Reference: 21.185r03v01

3 June 2022

Re: St Aloysius – Rozelle Campus
Response to Request for Information

Figure 12: Pick Up and Drop Off Location

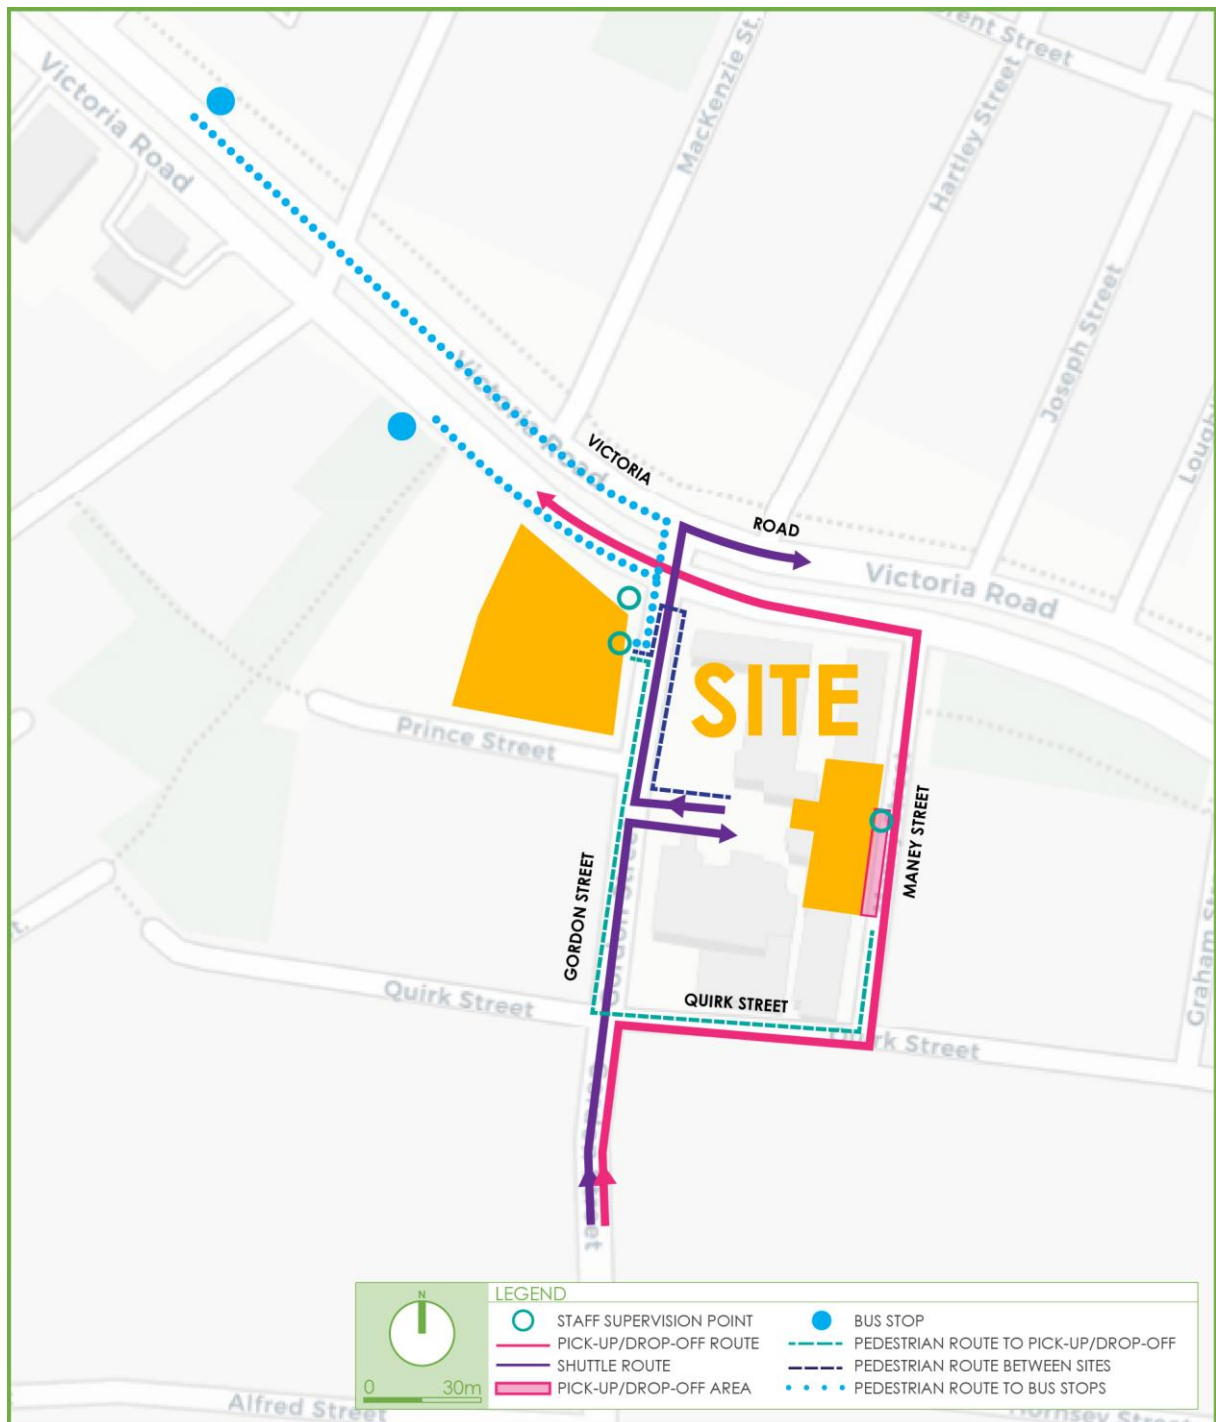
- i) *The proposed pickup and drop-off arrangements in Maney Street remain an issue. Even with the relocation of the area to the north in Maney Street, the narrow road width indicates that queuing of vehicles could occur, which will result in the temporary obstruction of the street. Alternatively, the queued vehicles may stay in 'No Stopping' areas at the corner of Maney Street and Quirk Street, which is an issue and could encourage unsafe pickup and drop-off practices. Although the response indicates that the pickup and drop-off areas will be staffed, this area is approximately a 150m walk to the school campus, which may be a challenge to be adequately managed by staff.*

- ii) *The TAIA indicates eight vehicles during a 30-minute period, which is a concern, particularly during the afternoon pickup period. The likelihood of the pickup and drop-off areas being filled to capacity remains a safety issue for Council.*

- i) As discussed in detail within the TAIA, the modal and catchment analysis determined that eight (8) students are anticipated to use drop-off and pick-up spaces under a worst-case scenario where it is assumed that all students that are ineligible for a travel pass are dropped off and picked up from school.

The development proposes a total of three (3) on-street set down spaces. As all students that would use these spaces are high school students, it is assumed that they would need minimal assistance to leave/enter the car. As such a two (2) minute dwell time is assumed for each vehicle using these on-street spaces (being a conservative estimate). Application of a two (2) minute dwell time on the three (3) proposed on-street spaces over the half hour period prior to or after school beginning and ending, results in a turnover capacity for up to 45 vehicles. Therefore, these spaces will not reach capacity based on the expected number of vehicles and queuing is not expected to occur during school pick up and drop off.

- ii) The school proposes that a staff member supervise these three (3) spaces in the half hour period before and after school times to ensure that vehicles accessing these spaces do not park longer than necessary. This will ensure continuous turnover which will provide sufficient availability to prevent any potential for queuing.
- iii) The school proposes to supervise students arriving to and from school to ensure the safety of students. This will actively prevent students from jaywalking across Gordon Street via management measures. This would be supported through communications within the school at assemblies etc. Therefore, fencing is not considered necessary, with the proposed management strategies including supervision to implement the above management measures.

Car Park Mark Up p

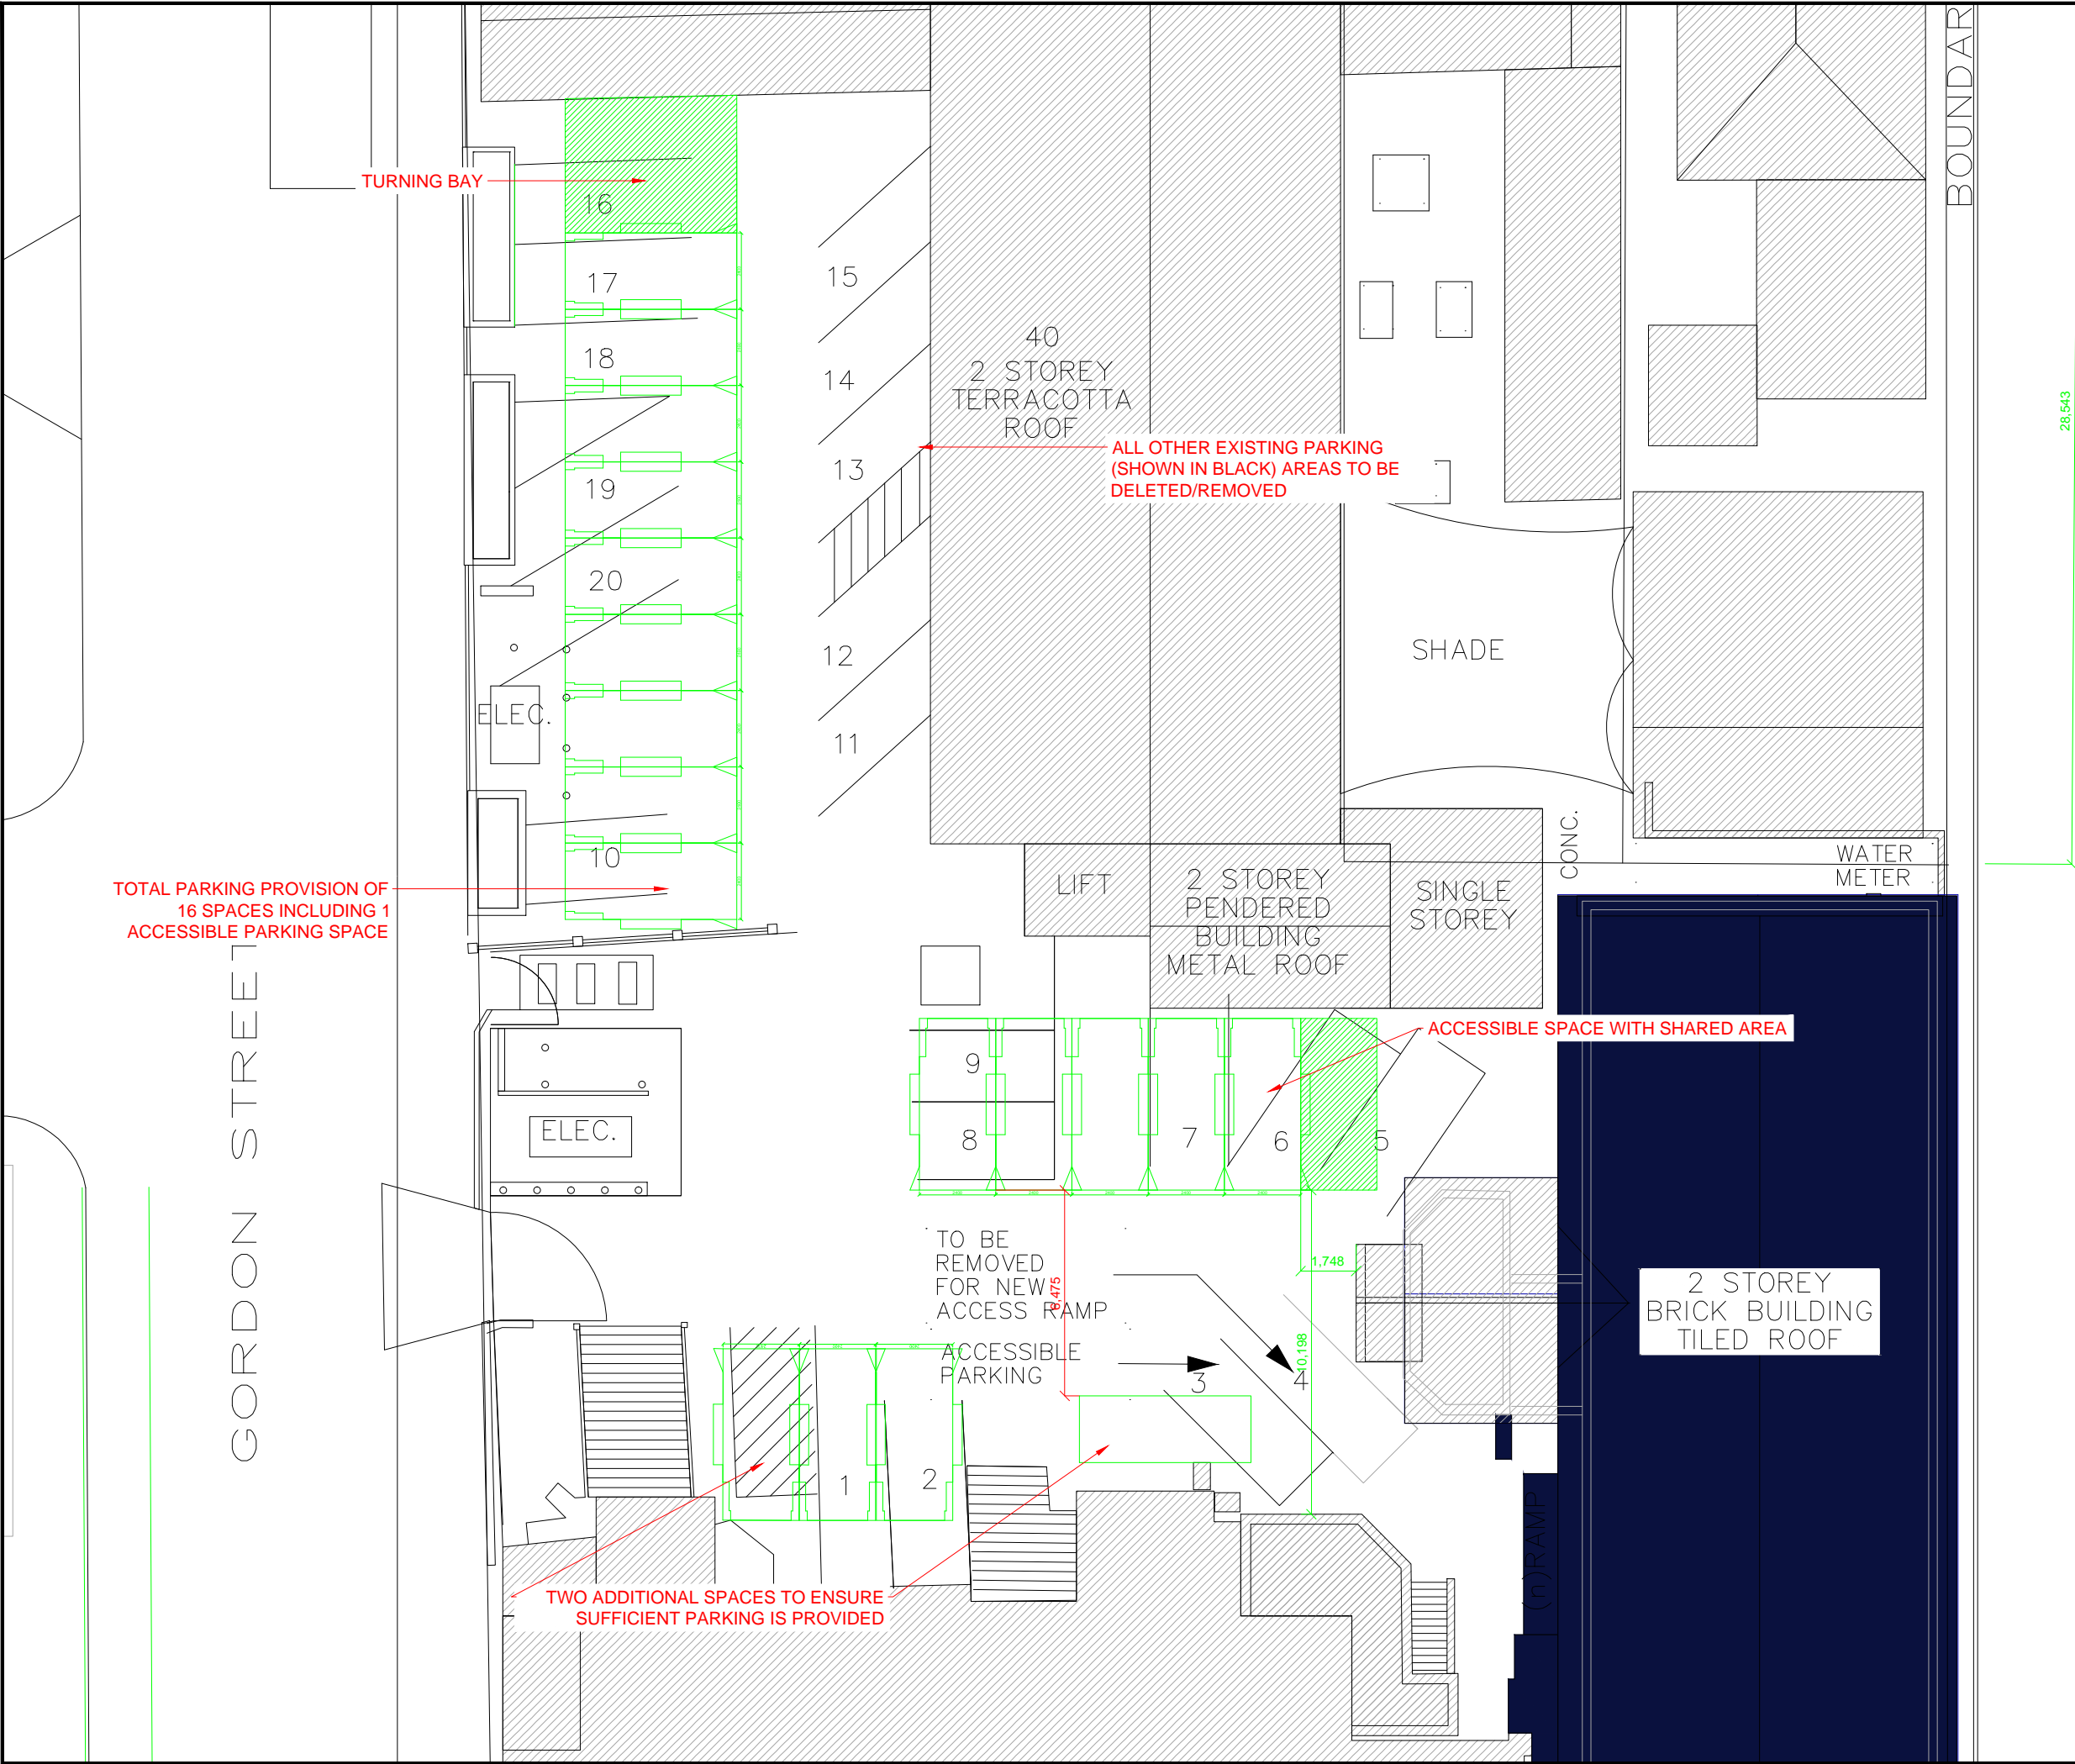
- i) The previous consent on the site required the carpark to be upgraded to comply with AS2890.1:2004. Appendix C of the TAIA details the new compliant layout, which reduces the on-site parking availability from 20 spaces to 16 spaces. However, the TAIA does not acknowledge the reduction in on-site parking and the impact this will have on the off-street parking demand.

- ii) The parking demand statement at Appendix D also does not account for the reduction in parking as evidenced by the table provided by the applicant (Table 1). Based on this table, it appears that the peak on-site demand is 21 spaces while only 16 spaces are provided. This shortfall will need to be addressed in the TAIA.

- i) The school is now proposing two (2) additional spaces to be line marked within the carpark. This will provide a total of 18 spaces for all uses on site. Therefore, up to three (3) spaces will need to be accommodated on-street. The analysis of the parking surveys within the most recent TAIA demonstrates sufficient capacity for this to be accommodated.
- ii) The shortfall of three (3) spaces can be accommodated on-street and this is now addressed in the TAIA. Please refer back to the TAIA for a detailed analysis of the parking surveys.
